DRB Application No.: 03-01230 (SBP)  
Project Name: PTI ELEC. CONTRACTORS  
Agent: Miller & Associates

**CITY OF ALBUQUERQUE  
PLANNING DEPARTMENT  
Development Review Board  
July 30, 2003 Comments**

**Project # 1002832**

**RE: PTI Electrical Contractors**

JOB NO. 0825
 DATE Jul '03
 REVISION
 DRAWN BY J.W.M.
 CHECKED BY
 SHEET TITLE BUILDING ELEVATIONS
 MILLER AND ASSOCIATES ARCHITECTS PLANNERS
 5220 SECOND STREET N.W. ALBUQUERQUE, NEW MEXICO 805/945-1312
 JOB TITLE PTI ELECTRICAL CONTRACTOR ALBUQUERQUE, NEW MEXICO
 E

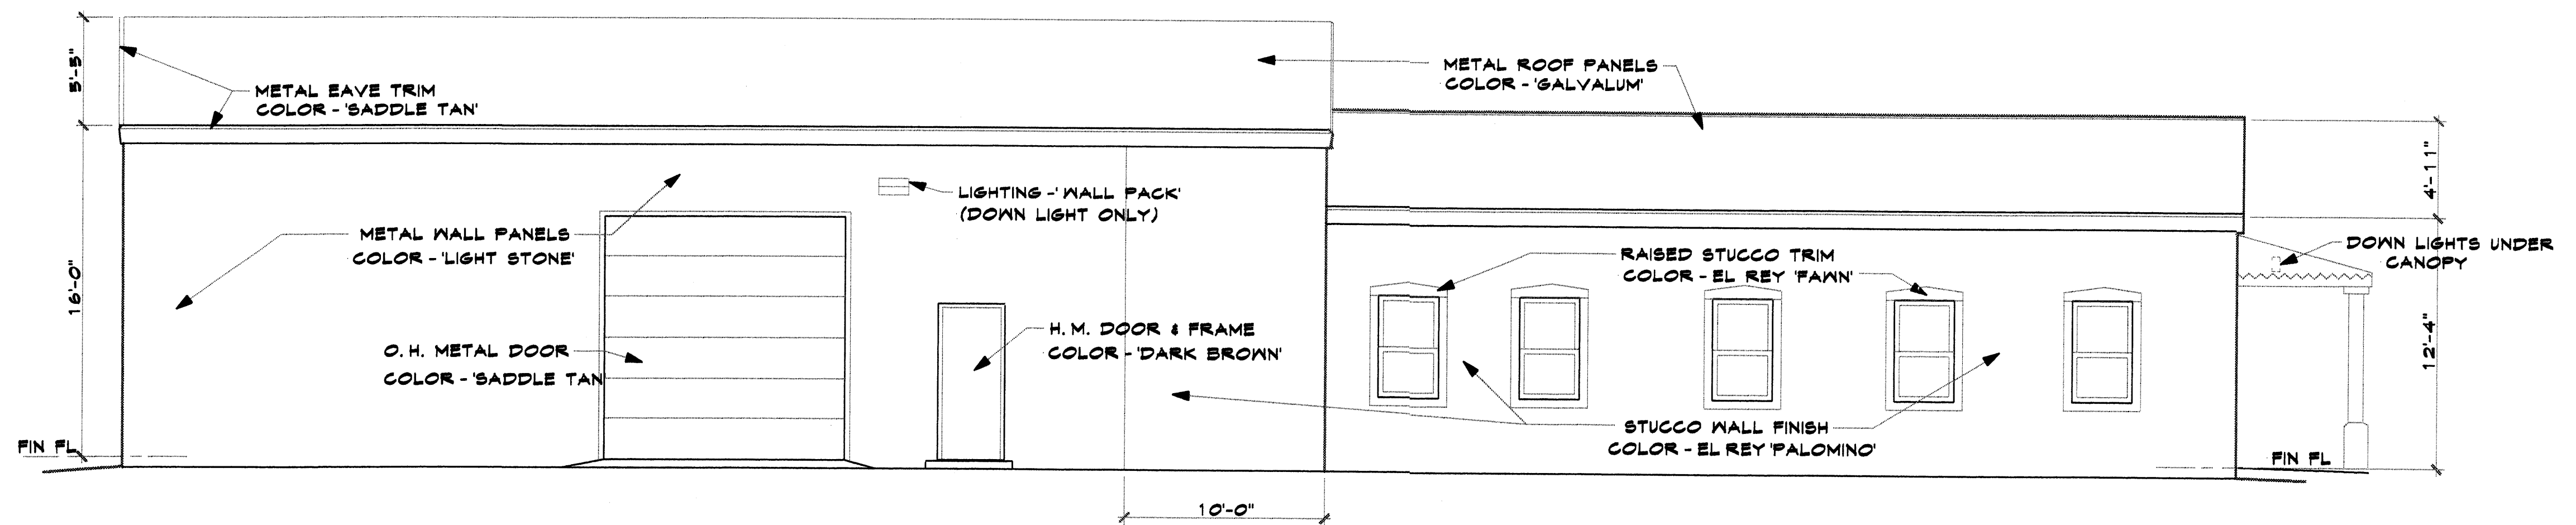
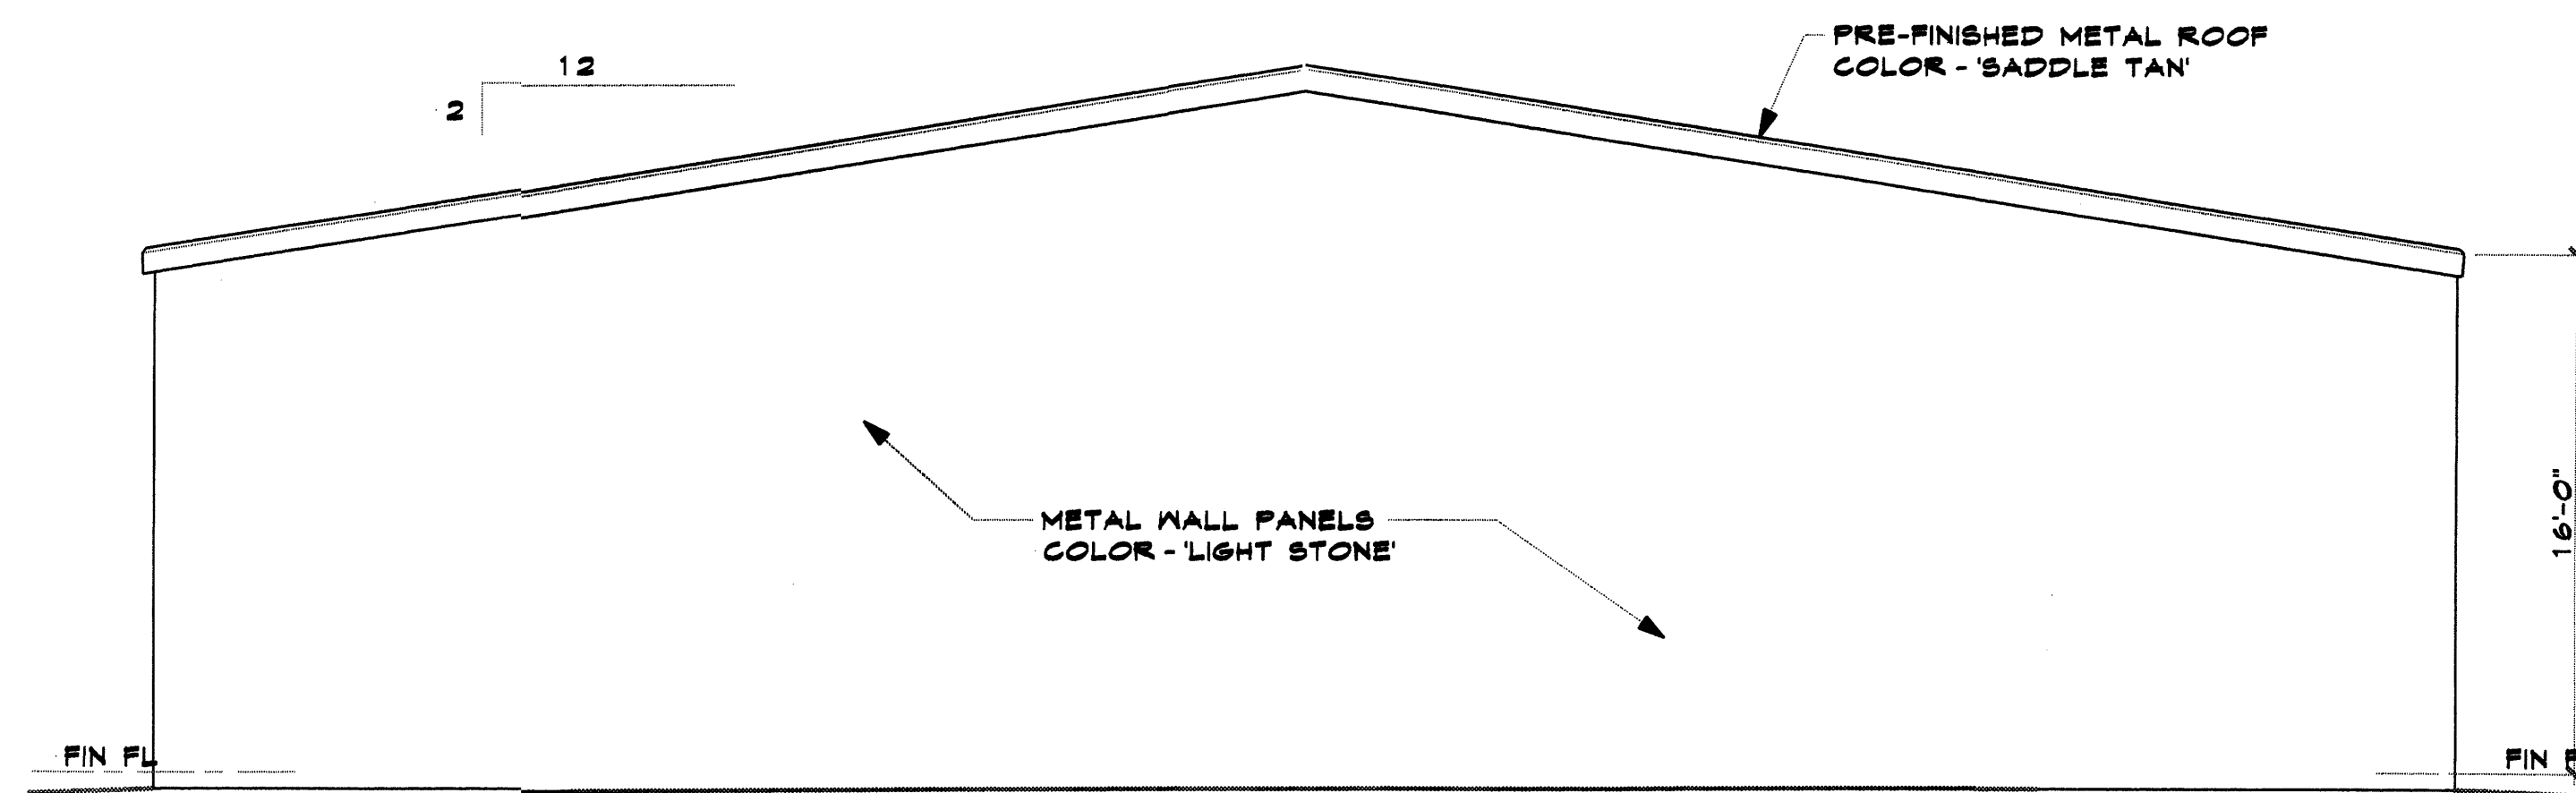
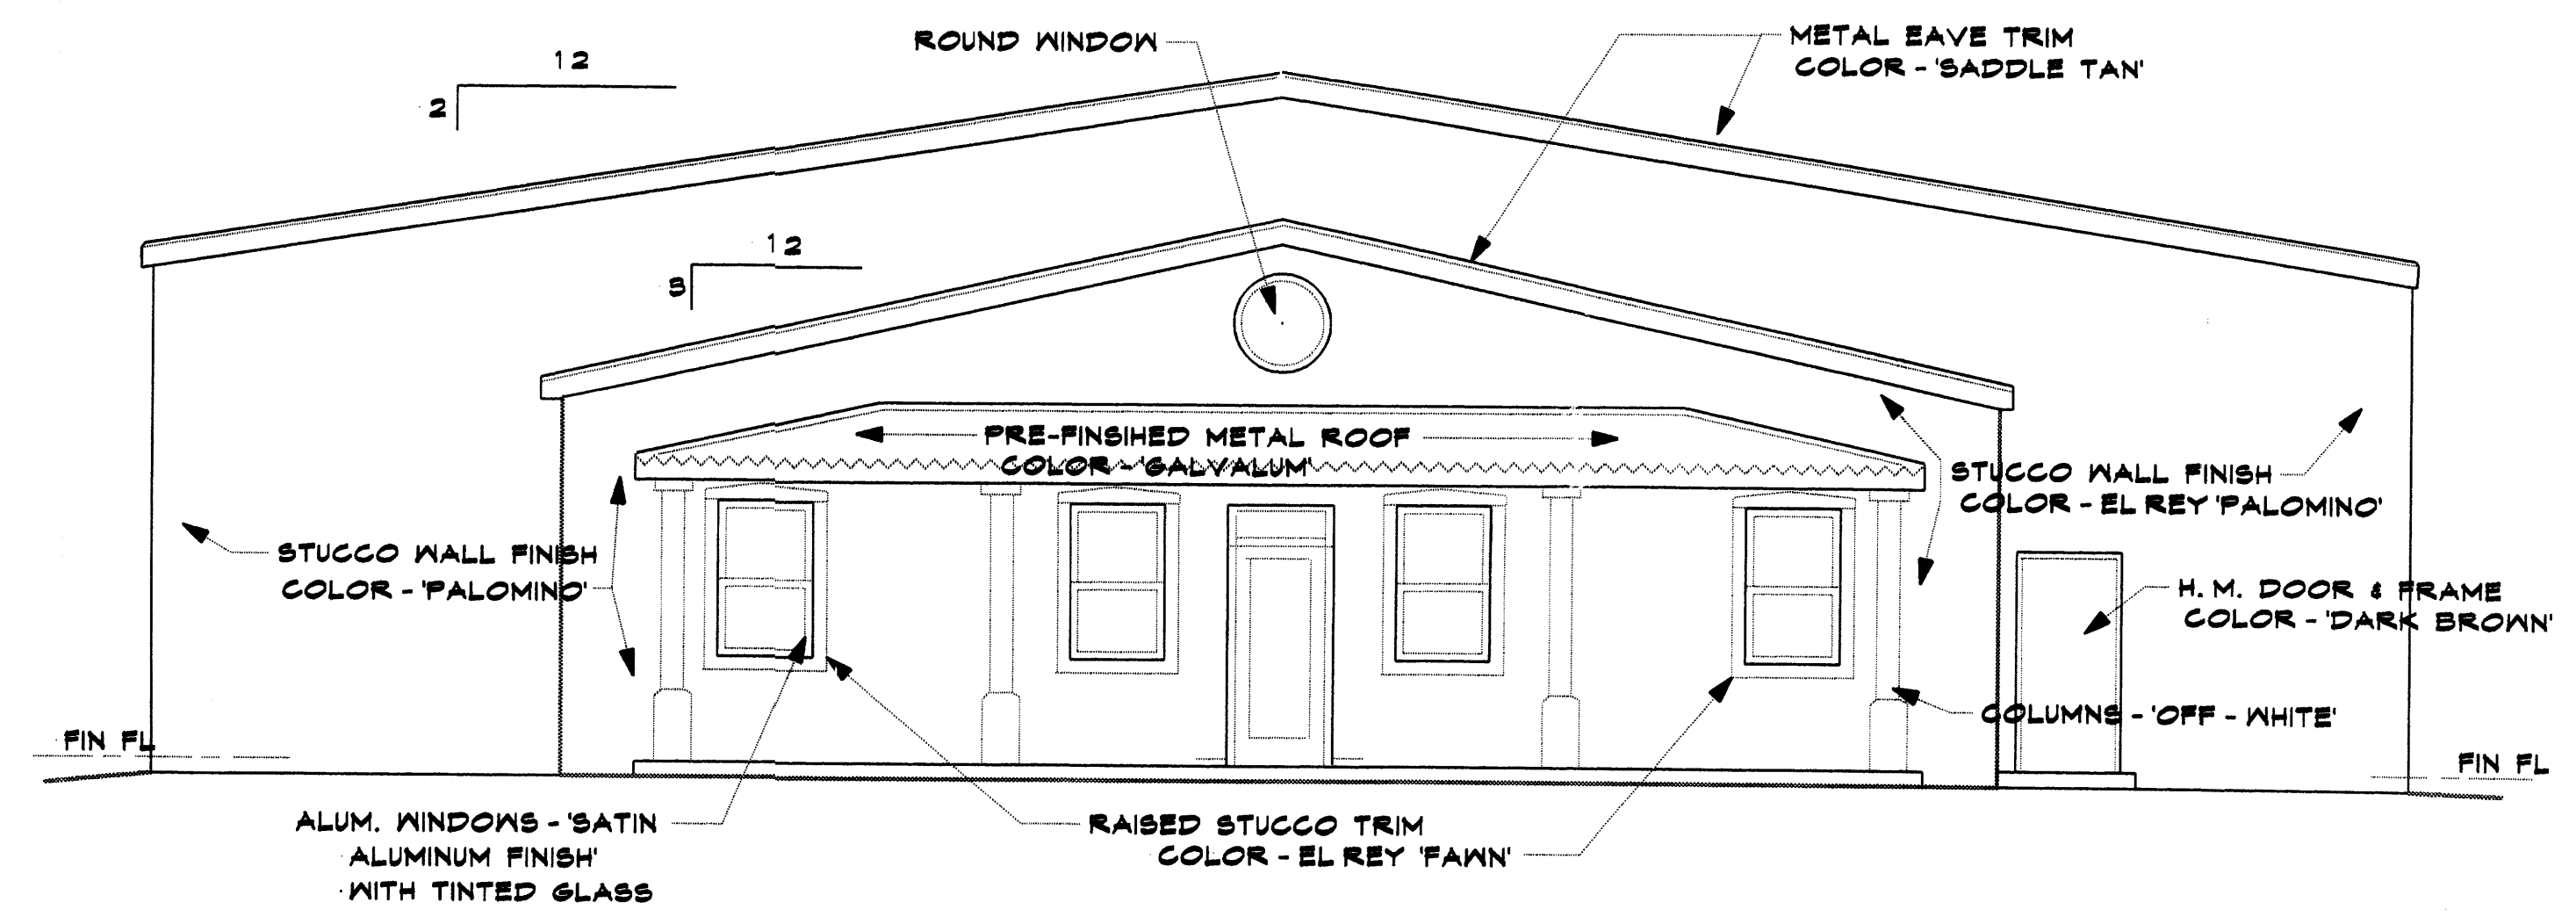
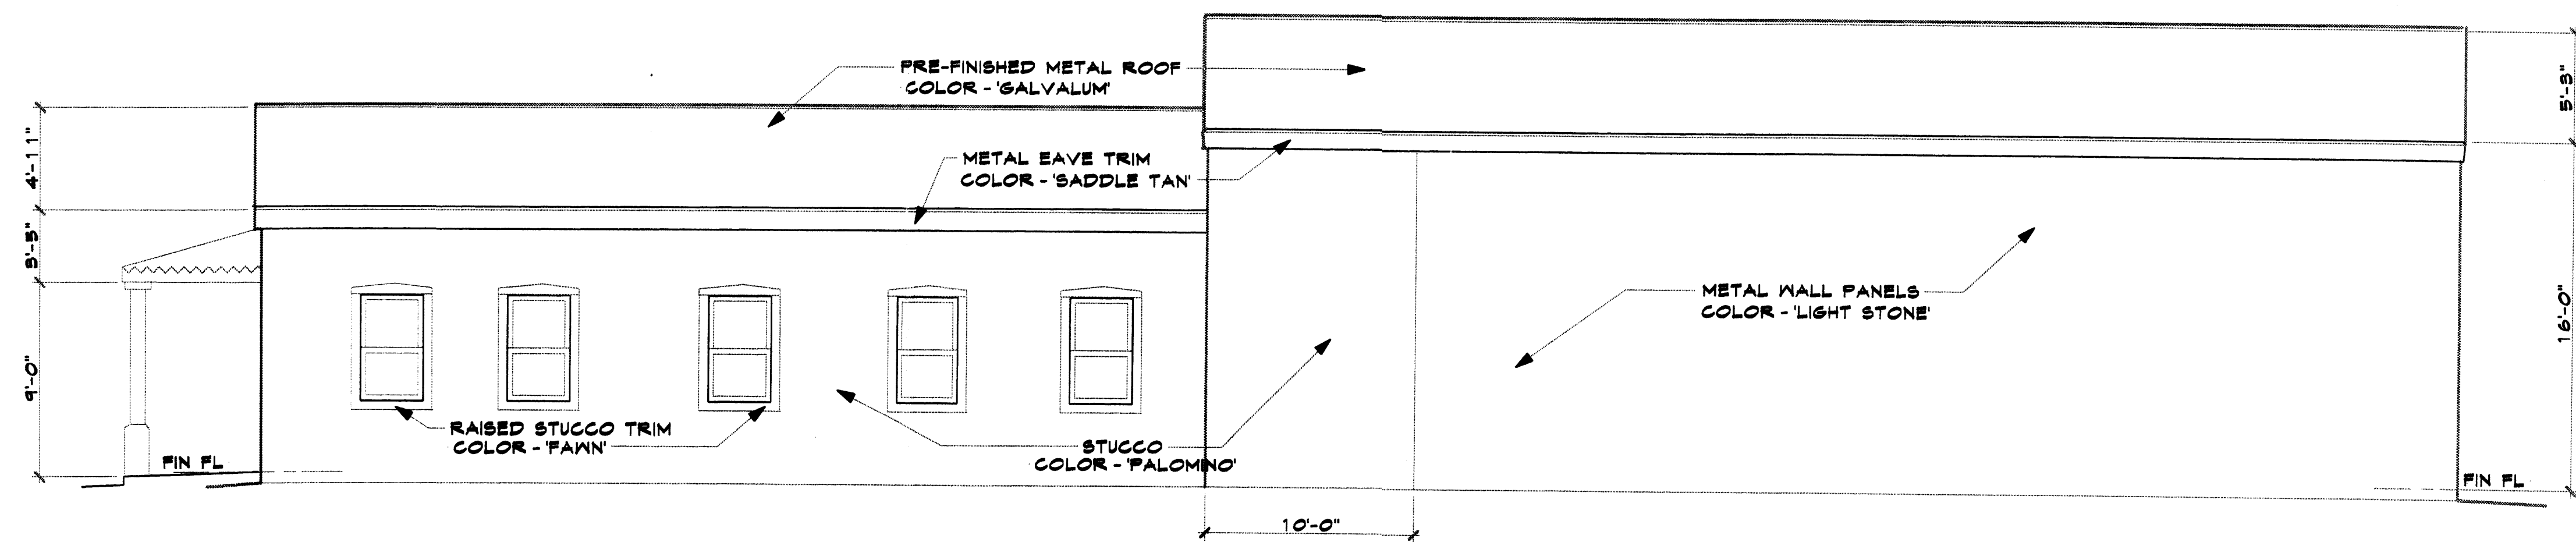
Is any building mounted signage planned? None is shown on the elevations sheet.

The Alameda Business Park Master Plan has lighting requirements for the parking lot as well as the site & exterior lighting. These conditions should be met via notes on the elevations sheet or the site plan itself. In addition, the Zoning Code has lighting requirements. Where these 2 documents, conflict, the Master Plan prevails.
